Our ref: RA/2025/148092/01-L01
Your ref: 2024/93366
Date: 24 March 2025

**CHANGE OF USE FROM B2 TO MIXED USED SITE CONSISTING OF B2 (GENERAL INDUSTRY), B8 (STORAGE AND DISTRIBUTION), CLASS E (OFFICES), CLASS F (LEARNING AND NON-RESIDENTIAL INSTITUTIONS), EXHIBITION / VENUE SPACE.
WILLOW LANE, BIRKBY, HUDDERSFIELD, HD1 5EB**

Environment Agency position

BASEMENT

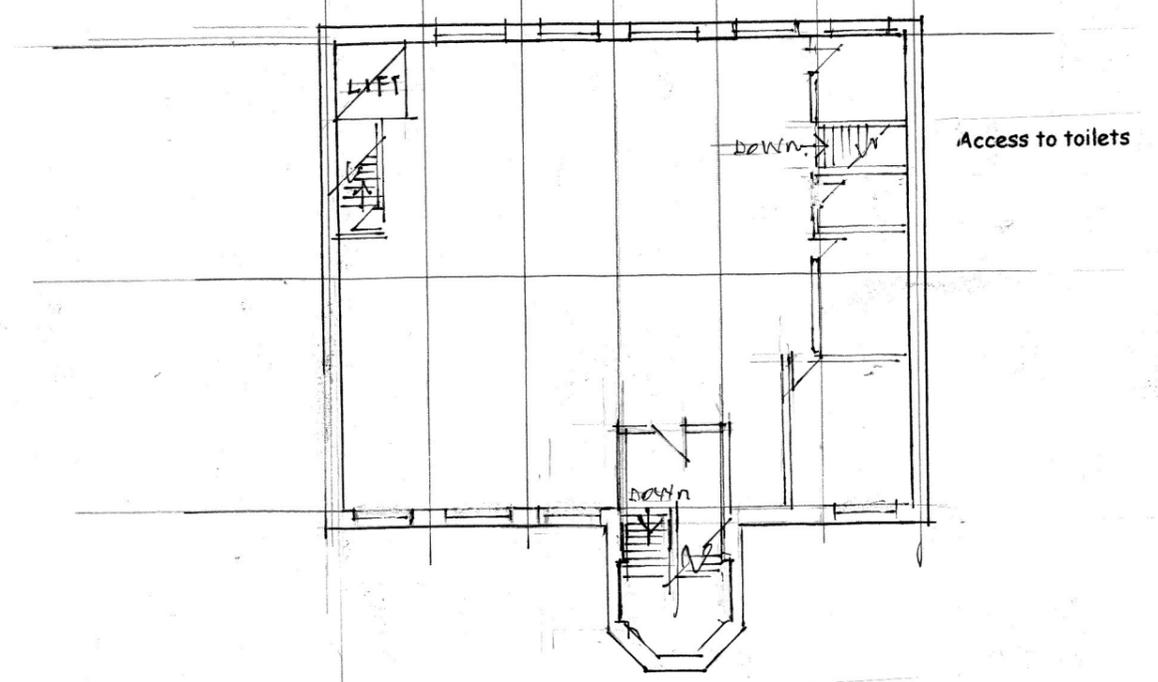
The proposed development introduces a new use to the basement of the existing building. The applicant must demonstrate that the proposals will not increase flood

risk to the site and its users. The applicant will need to clarify and evidence what vulnerability classification they consider the live music venue to be. For instance, if alcohol is consumed within the establishment this would be considered a More Vulnerable use.

To overcome our objection, the applicant should submit an FRA which demonstrates that the development is safe without increasing risk elsewhere. Where possible, it should reduce flood risk overall.
